From: [REDACTED]
Sent: 20 July 2017 10:03
To: Planning.Responses
Cc: Andrew Wood; Gary Markwell
Subject: LU/140/17/PL - Proposed COU from B1 Business purposes to van sales - Unit 9, Minster Business Park, Courtwick Lane, Littlehampton - Highway Authority comments dated 29th July 2017

DATE: 20th July 2017

SUBJECT: LU/140/17/PL - Change of use from light industrial (B1 Business) to van sales (Sui Generis).

LOCATION: Unit 9 Minster Court Business Park, Courtwick Lane, Littlehampton, BN17 7RW

PARKING PLAN .

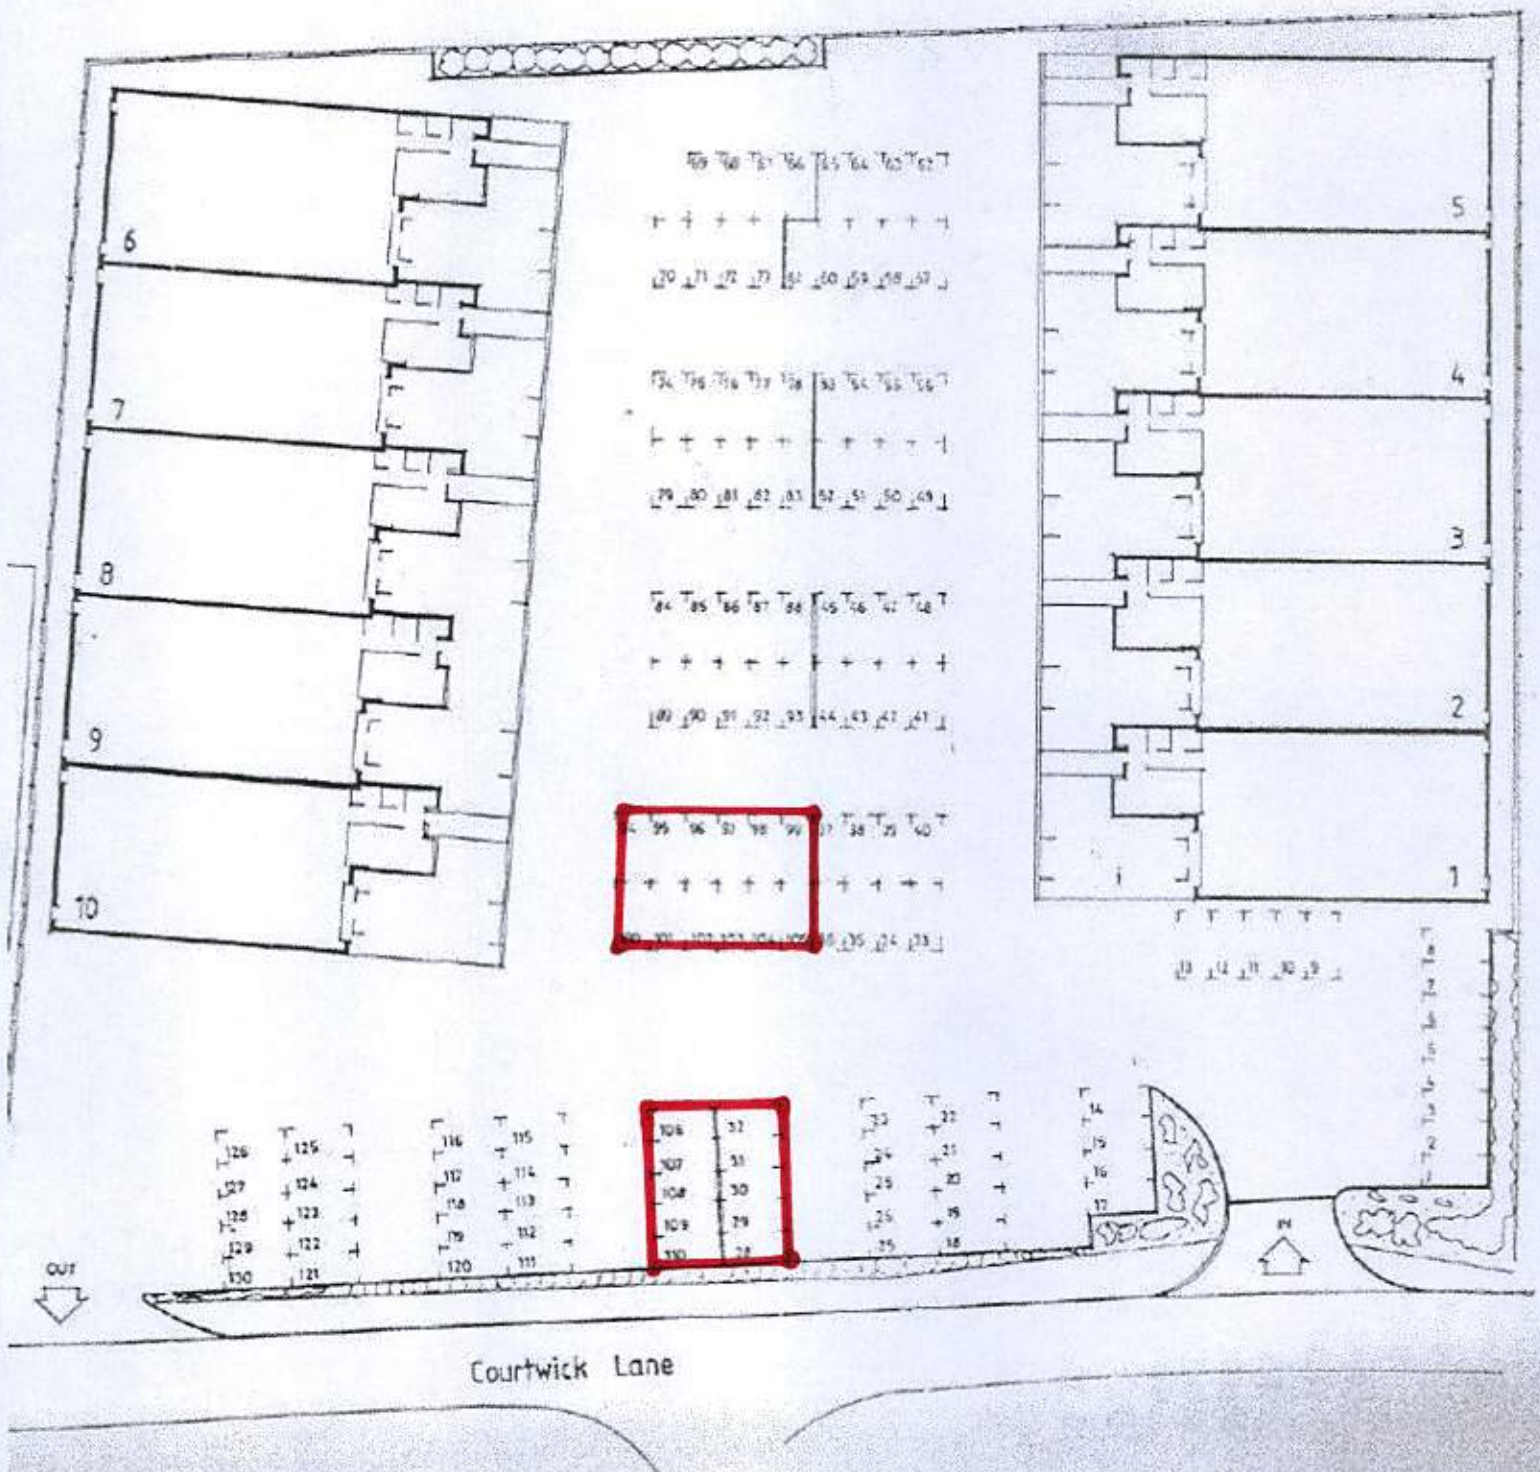
The applicant is seeking COU from B1 Business Use to car sales (Sui Generis) in Unit 9. They propose to use 22 spaces within the overall car park (not including any on-curtilage parking) and these are shown within red edging on the parking plan (No.'s 28-32, 90-99, 100-105 and 106-110).

From on-site observation, it is clear that the spaces are perhaps not quite as the parking plan shows. By that, it is observed that spaces 28-32 and 106-110 (shown back-to-back on the parking plan) seem to only be able to accommodate 8 vehicles and not 10 as would be the case if the plan was wholly correct. At the time of the site visit, the spaces were fully occupied by 8 vans – all for sale by the applicant with little or no spaces for further vehicles immediately next to them. Looking at spaces 94-99 and 100-105, this area was again taken-up by the applicant's vans numbering 10 and not the 12 as indicated by the parking plan. A further 5 vans were parked on the actual frontage of Unit 9 (total 23). It is not known if any vehicles were parked inside the building.

The CHA recommend a further plan be sought from the applicant clearly marking out all display, visitor and staff parking for the proposed use all within the confines of the Business Park site. Also, written confirmation from the landlord stating that the parking spaces applied for will be made available for specific use by the applicant all the time the site is used for van sales should be provided. These should then be forwarded to the CHA to consider. Parking for staff should be based on likely numbers likely to be employed on-site. It is suggested that visitor parking be provided based on likely demand. If this can all be demonstrated adequately within the site, a suitable planning condition would be recommended to secure it for the life of the COU.
